City of Albuquerque Stormwater Construction Site Inspection Report

ESC File No.	D10E002D	Project Name:	La Cuentiasta III & Stockpile		
NPDES Id. No.	NMR1004P9	Location:	Rosa Parks and Kimmick		
8/2/2022	Owner	Contractor			
Operator	Pulte Homes of NM	Guzman Construction			
Contact name & title	Kevin Patten	Rudy Guzman			
e-mail	Kevin.Patton@PulteGroup.com	rudy@guzmanacs.com			
Contact Phone #	505-341-8591	505-459-3128			
COA Inspector	Doug Hughes	Start/End Time:	7:45AM		
Construction Phase:	Staging				
Type of Inspection:	Regular	Storm Event	Past Storm Event >0.25"	311/Complaint	Follow Up
Weather at time of inspection?	Clear		Temperature: ~	81	
Estimated date of last storm 0.25" or greater	7/24/2022

TEMPORARY EROSION AND SEDIMENT CONTROL PLAN

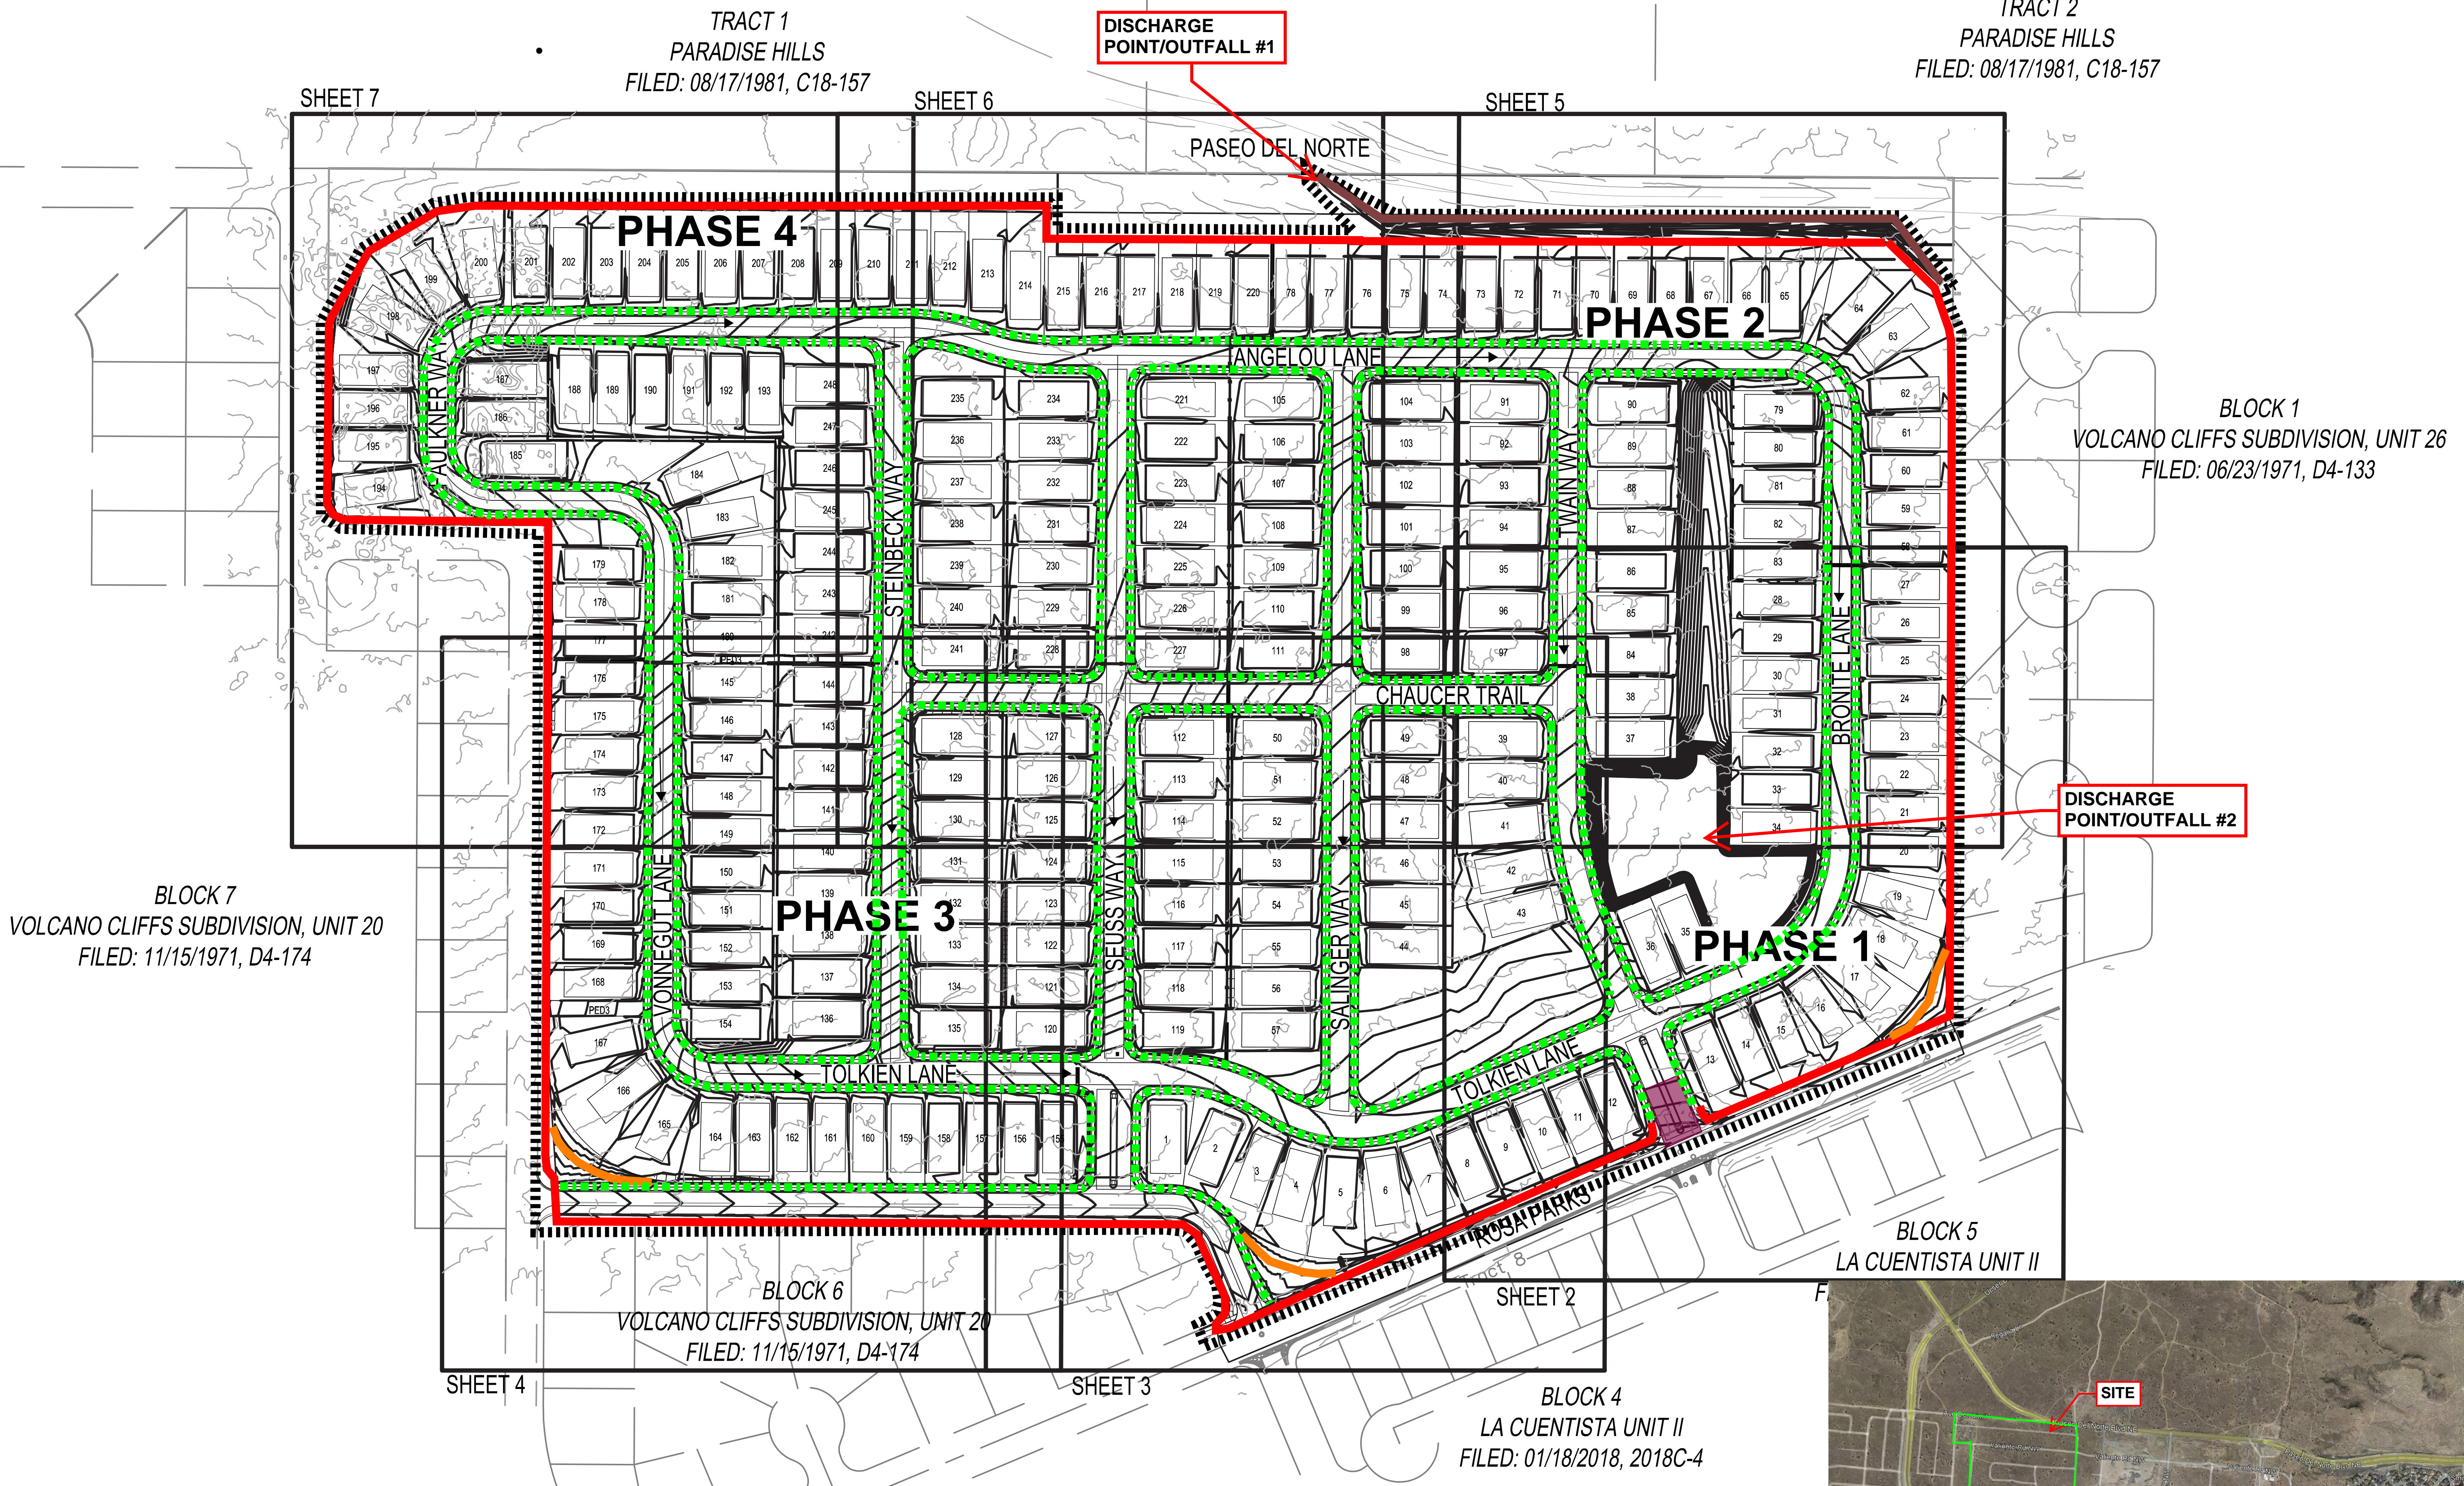
Item Number	Deficiency/ Corrective Action				
1	BMPs were missing at the staging/stockpile area.				
2	The property owner's NOIs are missing for the stockpile/staging area, so it doesn't have NPDES Permit coverage. NPDES Permit coverage is required for all disturbed areas. Tracts 1-5 Block 6 are entirely covered by recent land disturbing activities. There is also a large area of land disturbance on the portion of Tract 1 Blk 2 Plat of Tr1 Blk 2 Volcano Cliffs Subdivision Unit 26 that is due east of Tract 5 and where a water tank, porta potty, and other haul roads are located. An additional haul road is located on Tract 8 Blk 1.				
3	A SWPPP wasn't available onsite for the area of Construction Support Activities. Pulte's SWPPP didn't include the required information on the staging area (NOIs & SWPPP Map of BMPs) either. Pulte's SWPPP reports are not up-to-date. The Doc Box won't shut tightly, and SWPPP is being damaged by weather.

Notes:	
<p>The SWPPP is in the lockbox on Pulte's posting sign, and it is up-to-date, except the stockpile/staging area is missing. Eddie at Guzman said the new intent is to obtain permit coverage for only Tracts 4 and 5 in Block 6 and Tract 1 Block 2 and stabilize the rest with seed and aggregate mulch.</p>
